From: [REDACTED]@winchester.gov.uk
To: [Aquind Interconnector](#)
Subject: Aquind Interconnector: Secretary of State Consultation on further information.
Date: 12 August 2021 16:59:36
Attachments: [Secretary of State response letter August21.pdf](#)

Planning Act 2008 and The Infrastructure Planning (Examination Procedure) Rules 2010 Application by AQUIND Limited for an Order granting Development Consent for the proposed AQUIND Interconnector (“the AQUIND Interconnector project”)

Secretary of State Consultation

The micro-siting of the converter station at Lovedean

Figure 15.49: Indicative Landscape Mitigation Plan Option B(1) (south)

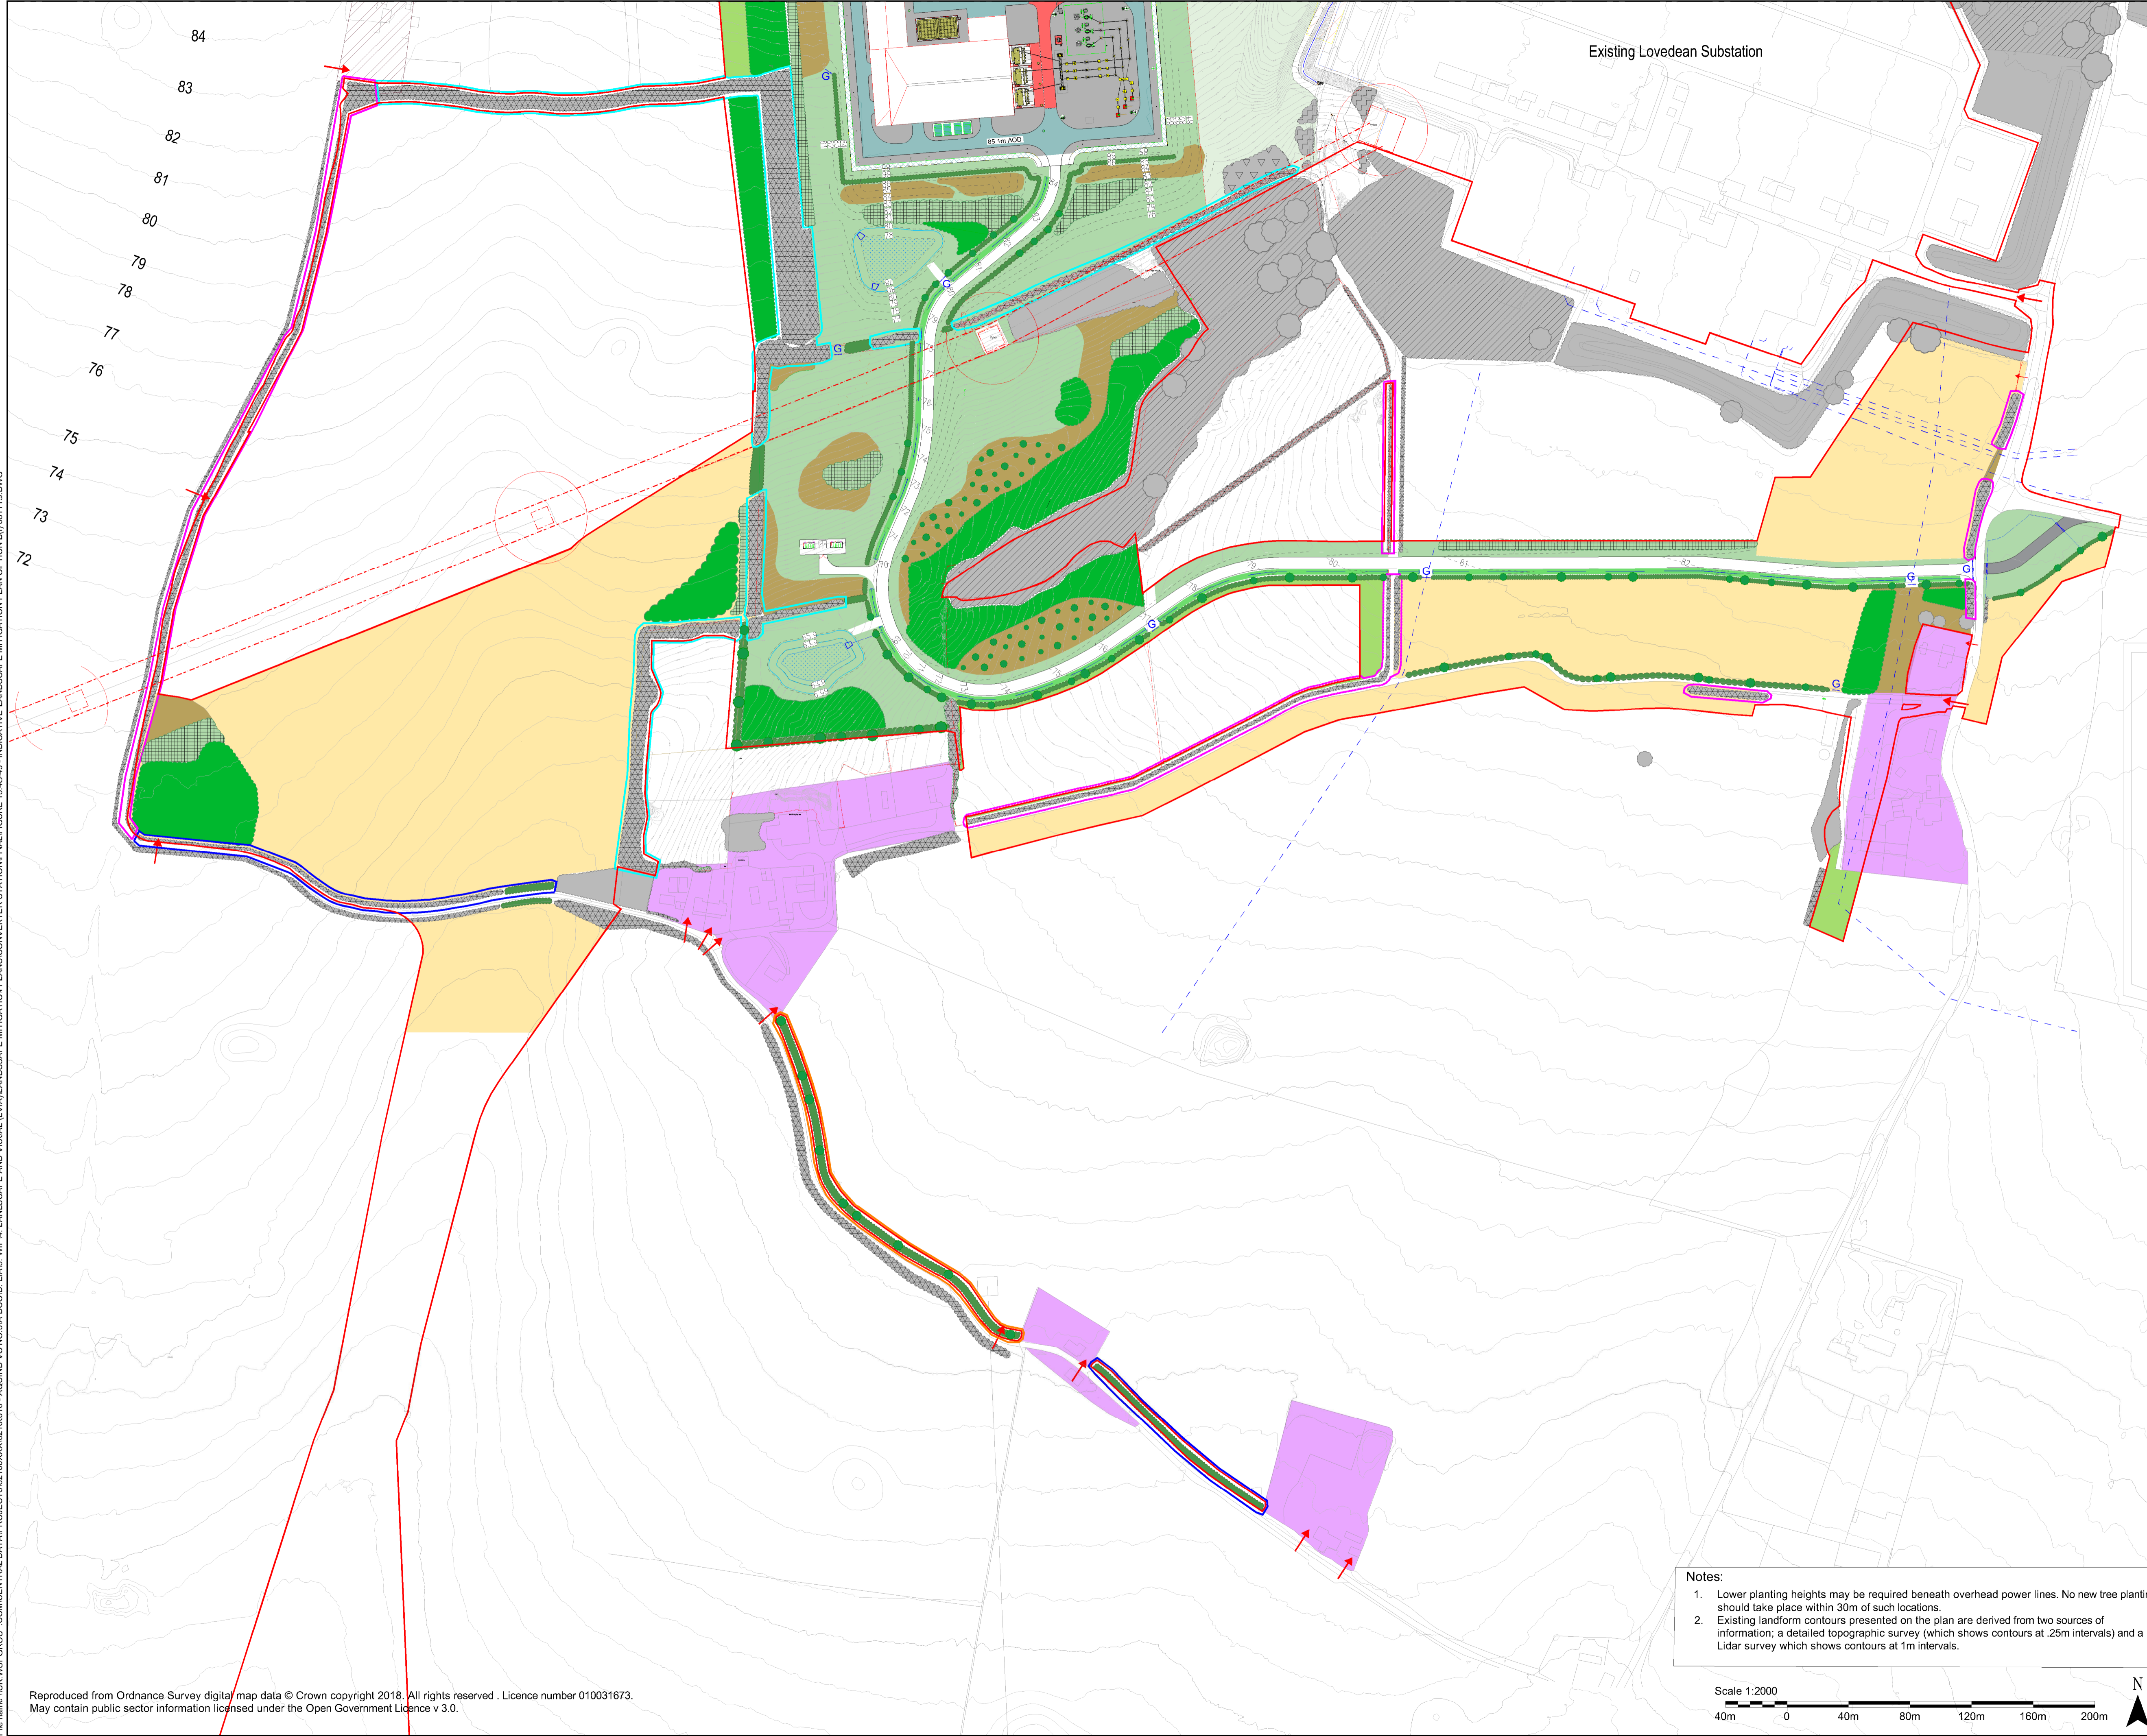
This adds up to approximately 410m of species rich hedgerow and 25m of hedgerow will be lost (16.6.1.13). This includes some mature trees. This will also result in the loss of its biodiversity value including the loss of habitat for bats (section 16.6.1.27). It has also been recognised that two badger setts will also be destroyed (section 16.6.1.21). This action would weaken the

landscape screen on the western side of the development removing the existing mature screen. This will be replaced by new planting as shown on Figure 6.10.1 Outline Landscape and Biodiversity Strategy Management Plan (APP-506). The new planting will obviously take time to mature into a condition that would provide the equivalent screening value and ecological value that the existing feature does.
